DECISION DELEGATED TO HEAD OF PLANNING

Application No: H04-0586-22 **Applicant:** Mr G Barron

Proposal: Demolition of former British Legion Club building and erection of 6 detached bungalows, garages and access road - approved under H04-0905-20

Location: 3 Malting Lane Donington Spalding

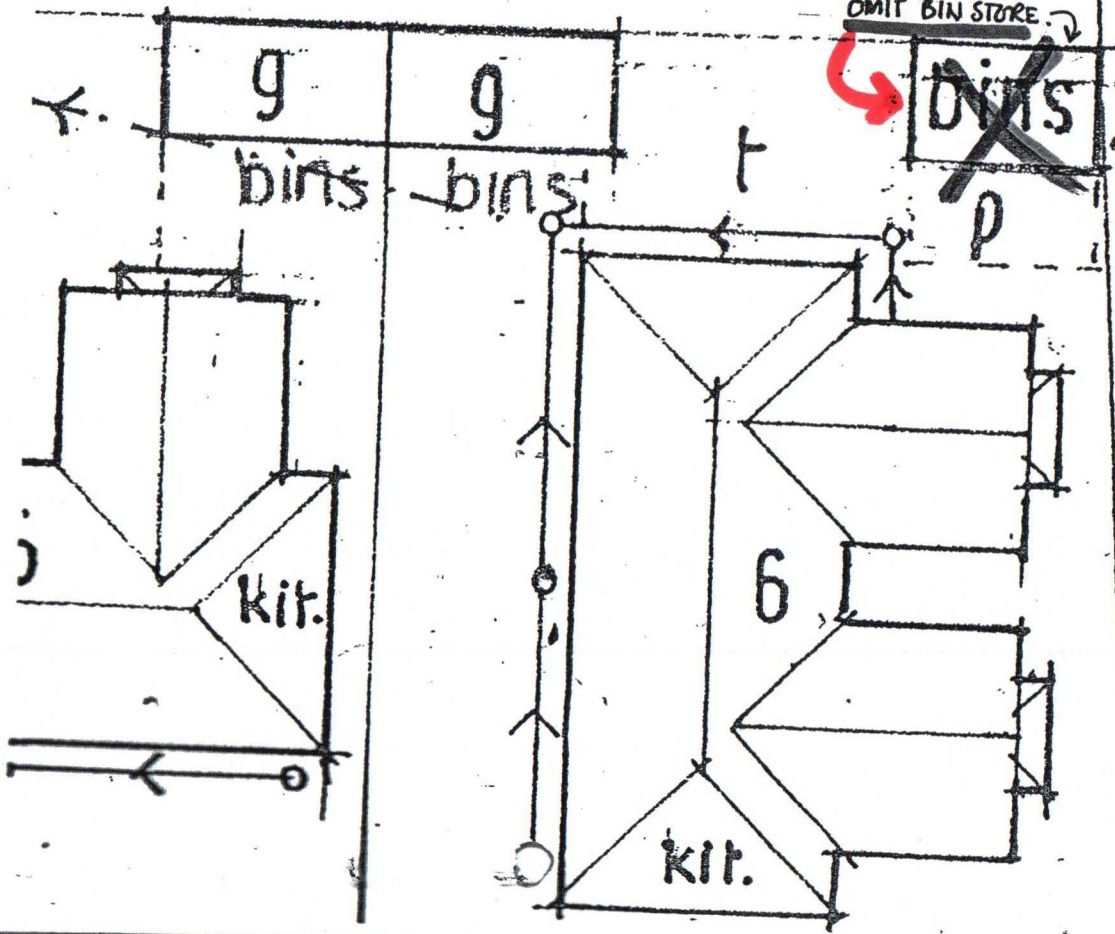
"The new position of the bin store is against a neighbour's fence and very close to the pavement and will cause issues with obstructions and will be open for flytipping."

Proximity to properties outside boundary.

Potential for bin smells.

Potential for vermin.

We oppose any bin store wherever it is sited.

11. Residential amenity is not considered to be materially impacted by this proposal. Overlooking and overshadowing will not affect neighbours due to the single storey nature of the dwellings. The proposed bin store if used appropriately should not impact the character or amenity of the area. It is set back from the highway access so does not affect visibility.

Provision for the storage of recycling bins is to the front of the site on collection days with storage at individual properties for the rest of the week. The proposed bin store if used appropriately should not impact the character or amenity of the area. It is set back from the highway access so does not affect visibility. Whilst it is acknowledged that the relocated bin store would be located on a private footpath, there is adequate space to utilise the footpath without encroaching onto the adjacent private road. With regard to potential for smell and vermin, if refuse is placed on site on the morning of collection then this is not considered to be a material planning concern. As the bin store is sited adjacent to but not on the public highway then the County Highways & SUDS Department have not
